From: Hornby, Mark [Mark.Hornby@lancashire.gov.uk]
Sent: 22 March 2012 10:51
To: Graeme Thorpe
Cc: ENV EPP Customer Service Area East
Subject: FW: Consultation on planning application 3/2012/0061 Prospect Cottage, Lower Lane, Longridge
Graeme

The submitted plans detail satisfactory access, manoeuvring and parking arrangements and therefore I have no objection to the proposal, subject to the following conditions:

SITEPLANS

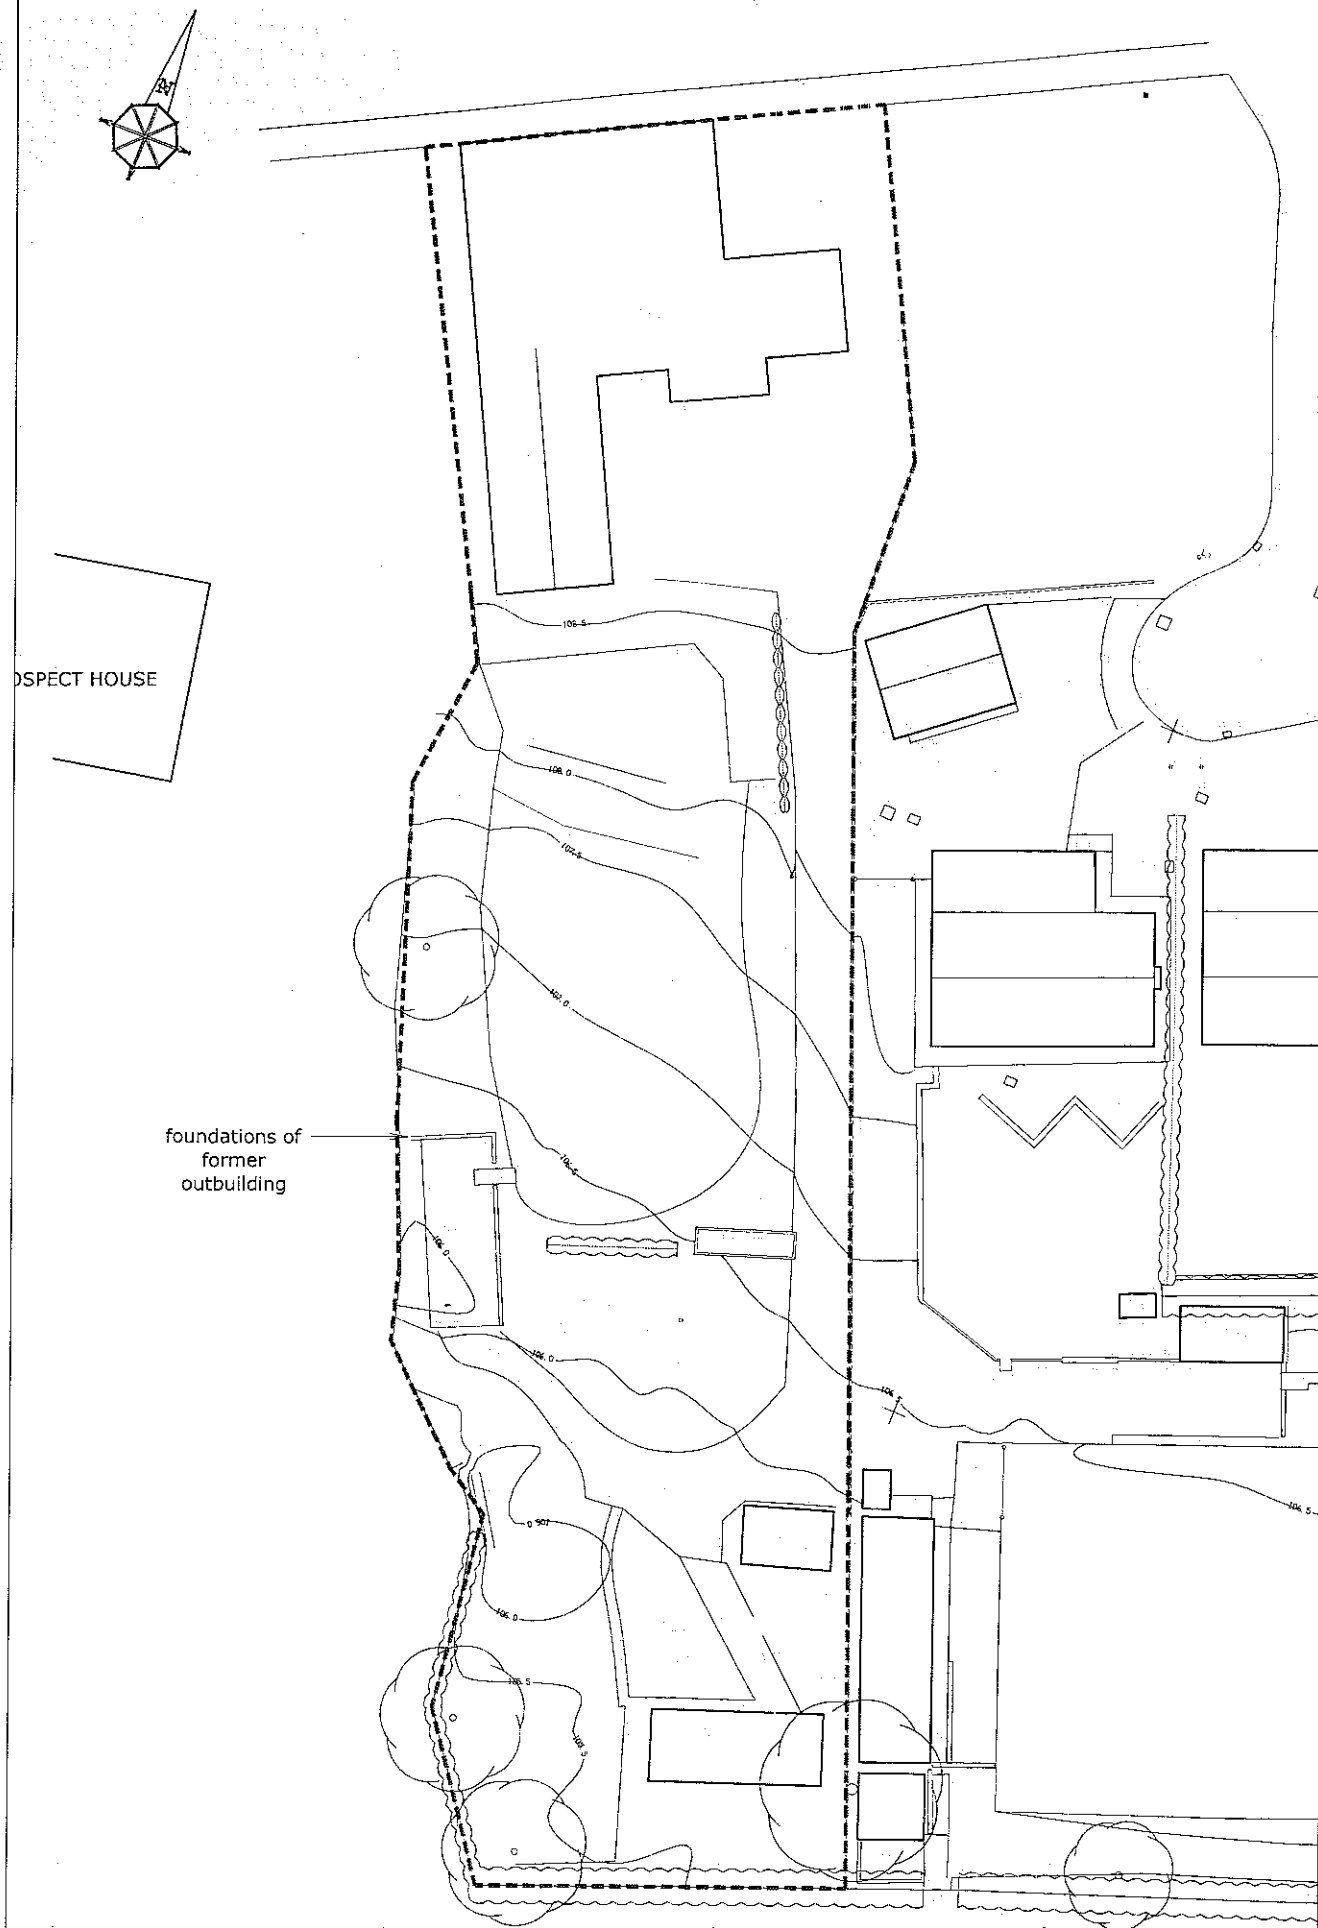
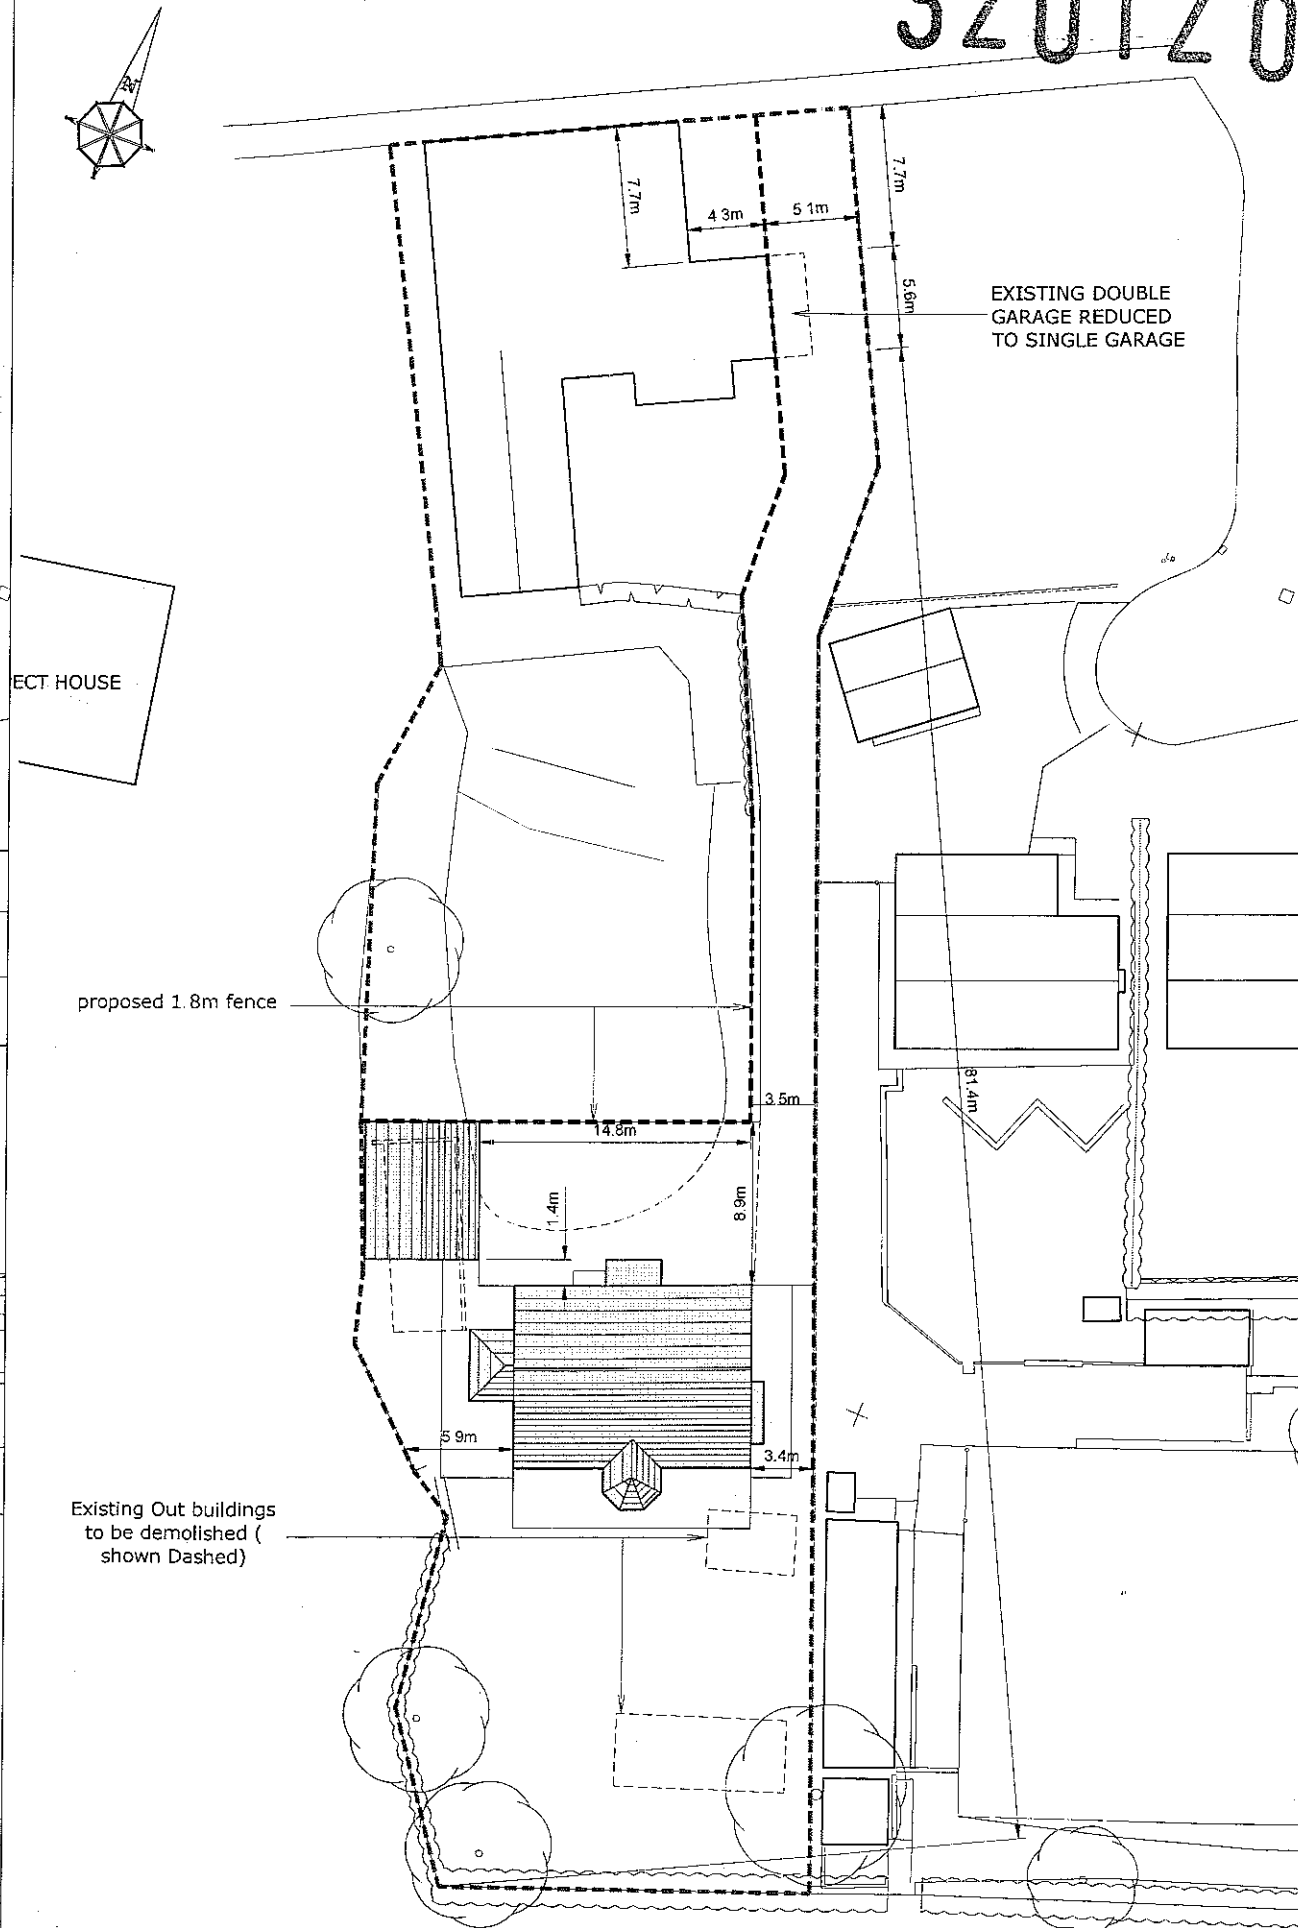
1. The widened driveway shall remain ungated where it meets the highway boundary. Reason: To permit vehicles to pull clear of the highway when entering the site and to assist visibility.
2. That part of the access extending from the highway boundary for a minimum distance of 5 metres into the site shall be appropriately paved in tarmacadam, concrete, block pavements, or other approved materials. Reason: To prevent loose surface material from being carried onto the public highway thus causing a potential source of danger to other road users.
